City of Portland, Maine - Building or Use Permit Application
 389 Congress Street, 04101 Tel: (207) 874-8703, Fax: (207) 874-8716

| Permit No: 05-1378 | Issue Date: | CBL: 331 A001001 |

| Past Use: COMMERCIAL CONDOS | Proposed Use: Commercial Condos/ install a hanging Lennox/Aire-Flo to building 8 | Permit Fee: \$228.00 | Cost of Work: \$22,253.00 | CEO District: 5 |
| Proposed Project Description: install a hanging Lennox/Aire-Flo to building 8 | | FIRE DEPT: <input type="checkbox"/> Approved <input type="checkbox"/> Denied | INSPECTION: Use Group: Type | |

1039 Riverside  
Buildings & Hangers detail

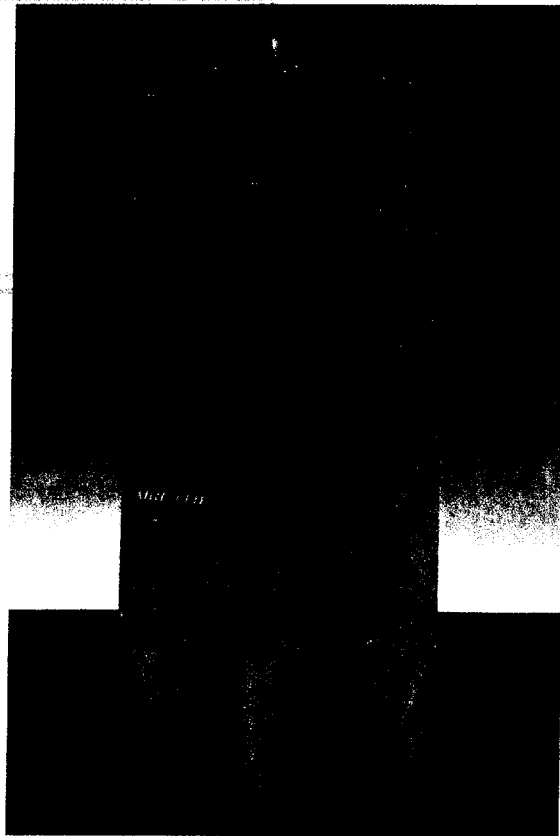
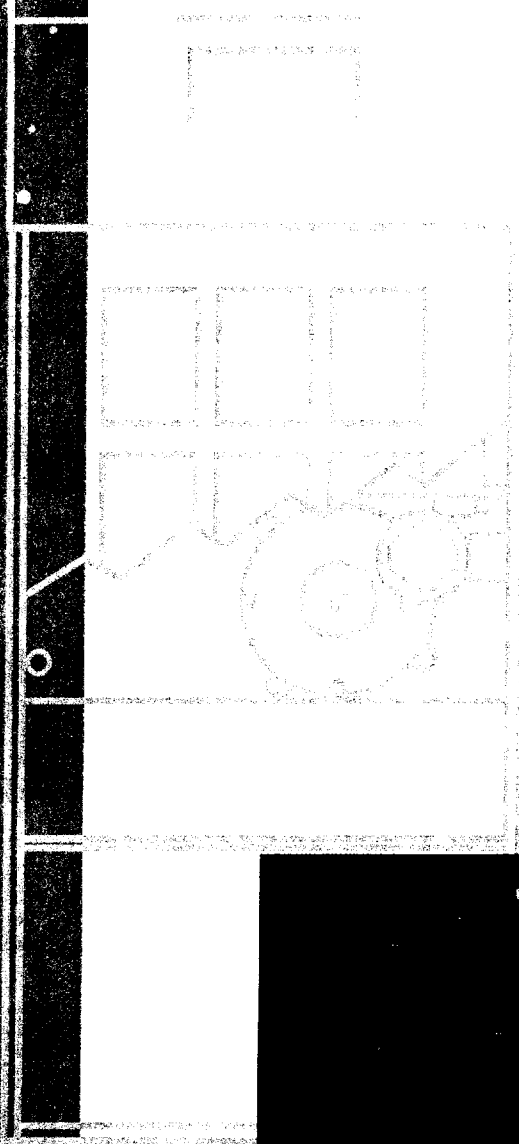
Comments:
10/20/05-tmm: left message w/ Air temp - need engineering on building for hanging unit
10/25/05-tmm: left message again w/Air temp
